An
Bord
Pleanála

Inspector's Report ABP-310567-21

Strategic Housing Development

198 no. BTR apartments and associated site works.

Proposed Ground Floor Plan
 1 : 200

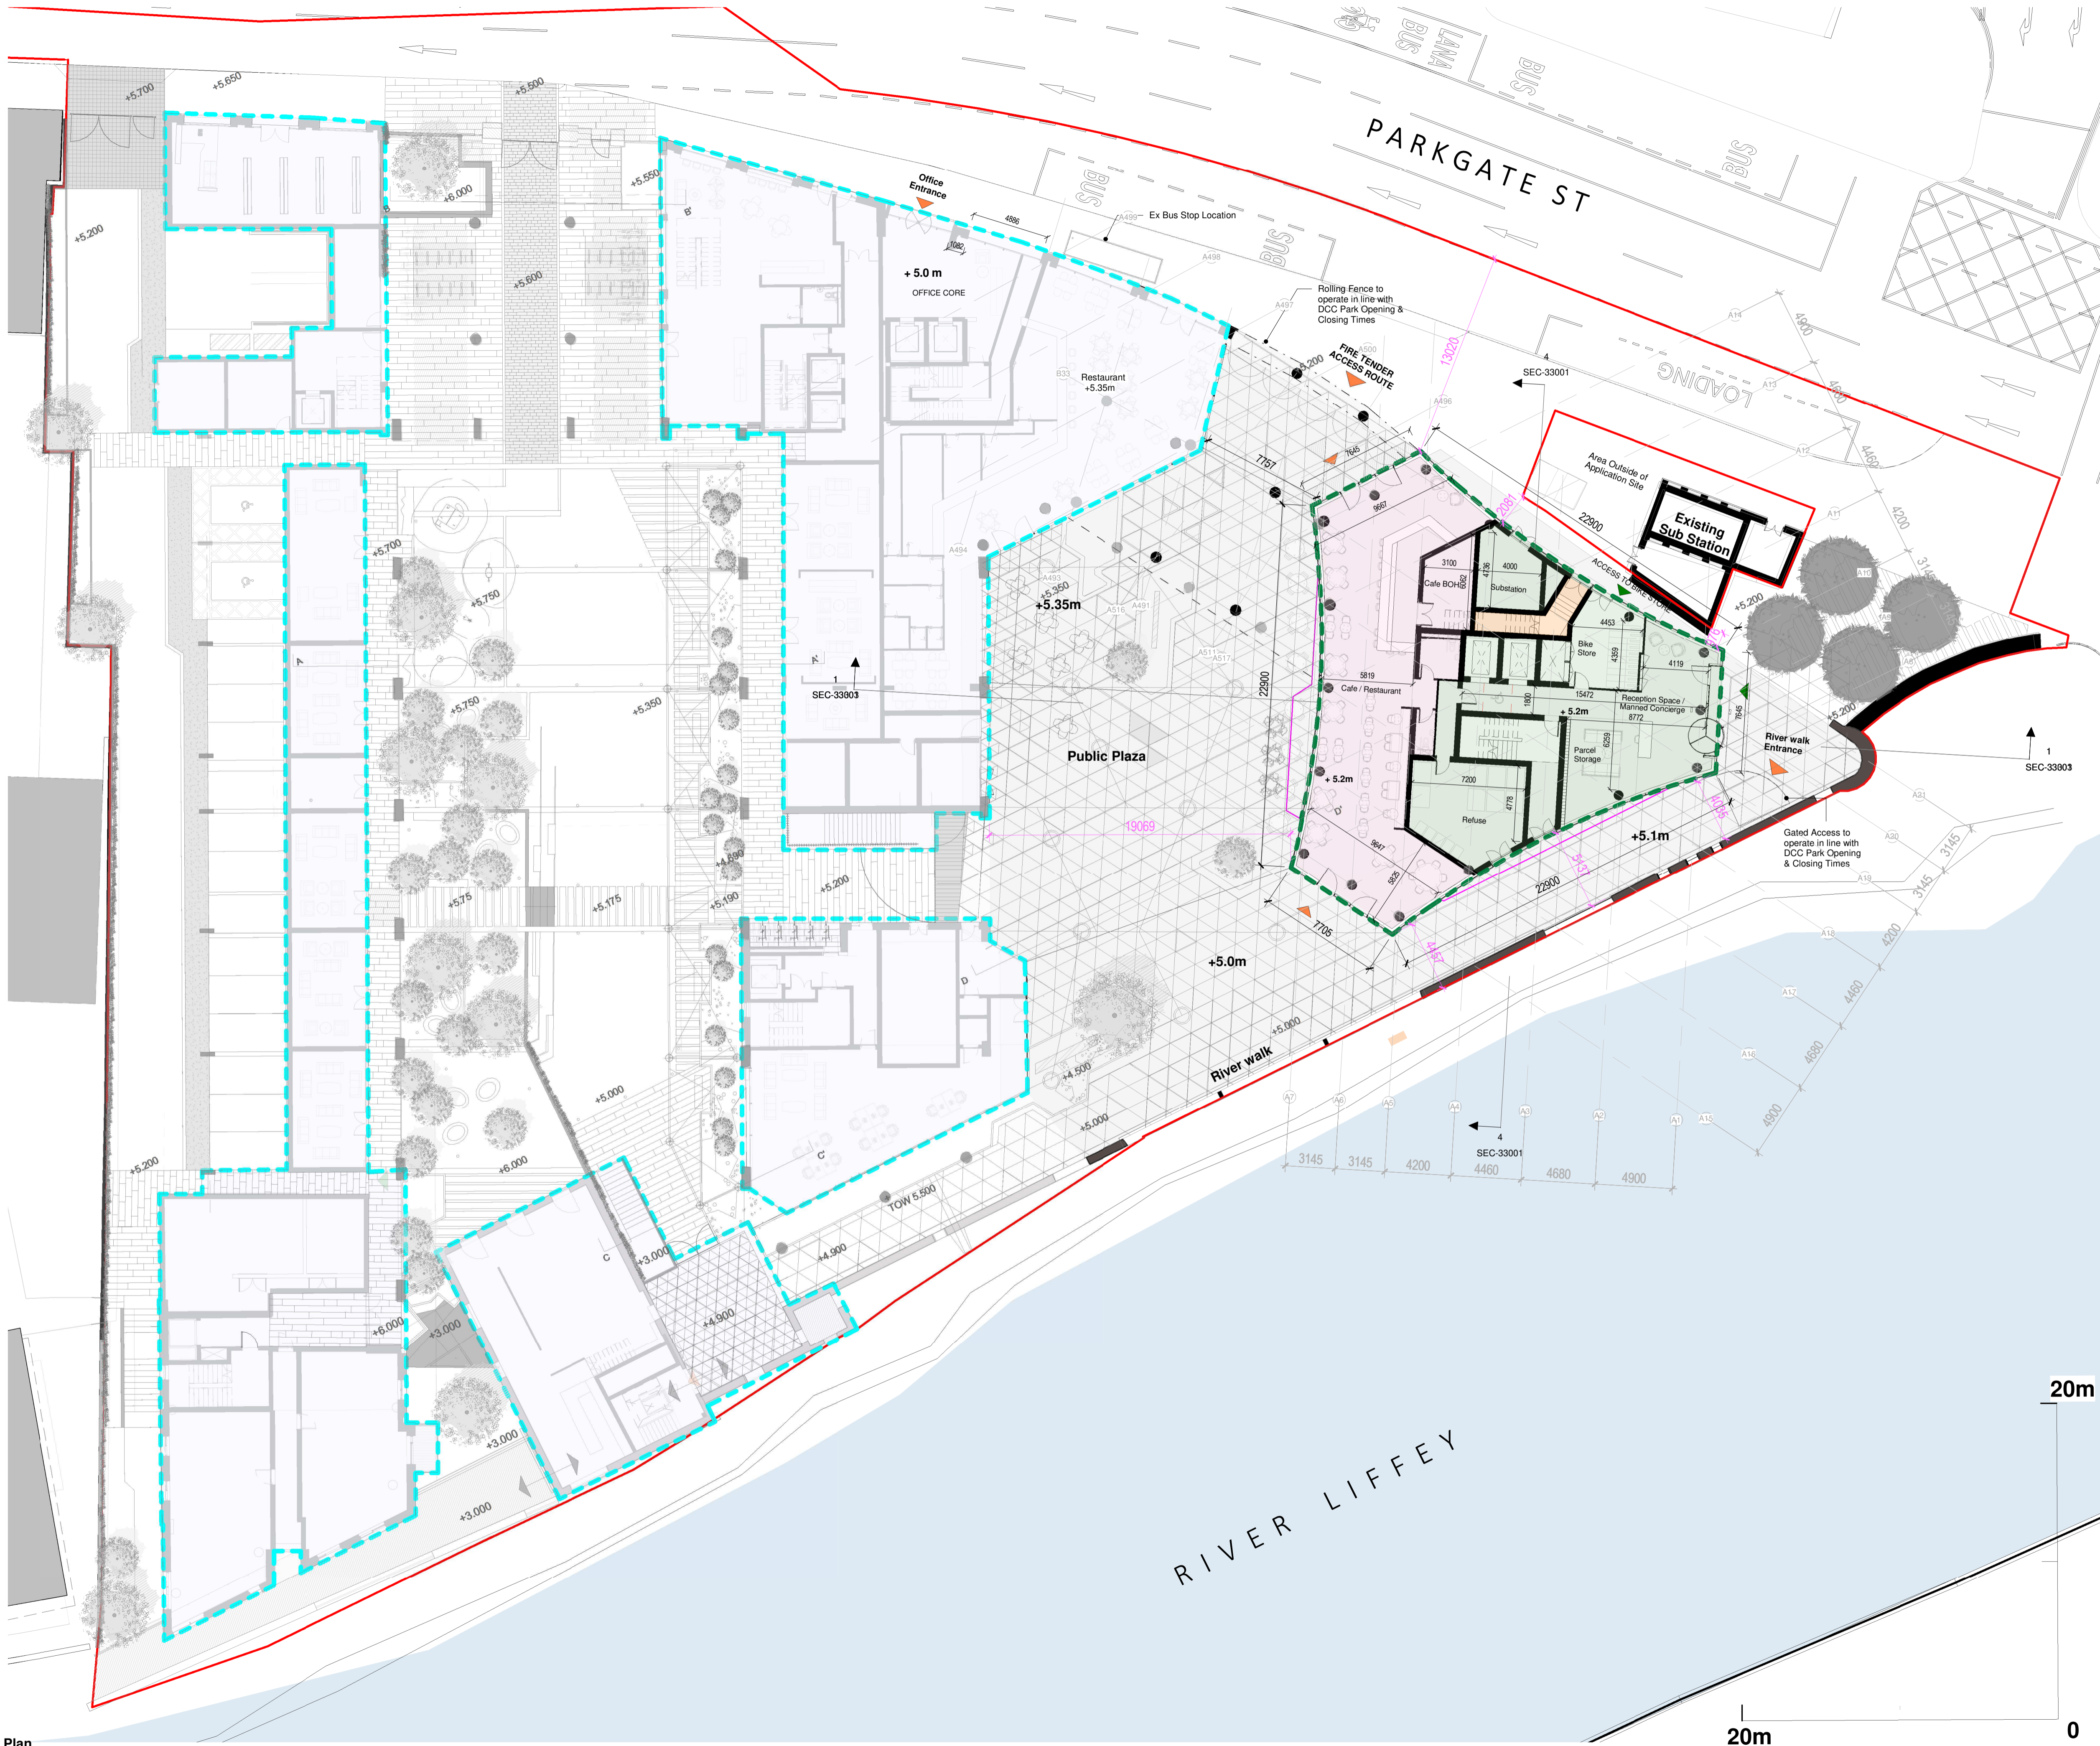
- There is no access to Block A from the main plaza.
- The entrance width into the public plaza from Parkgate Street appears to have been reduced by c. 3m.
- Minor layout tweaks are required for the fire tender access.
- It has not been demonstrated that the weekly waste storage requirements for Block A can be accommodated.
- The proposal includes a reduction in cycle parking spaces for the commercial element from 48 to 34.
- A reduction in the cycle parking provision was previously raised under ABP 306569-20 and it is not clear if the permitted and proposed cycle parking can be accommodated within the site.

- It is not clear if the 38 spaces are in addition to the permitted cycle provision.
- It is requested that an additional 10 visitor spaces and 4 cargo spaces are conditioned.
- Condition No 11 of the previous application ABP 306569-20 is considered appropriate in relation to the car parking and works to the footpath and carriageway.
- The landscape drawings incorrectly show the entrance doors for Block A as outward opening.
- The information in the EIA is noted.
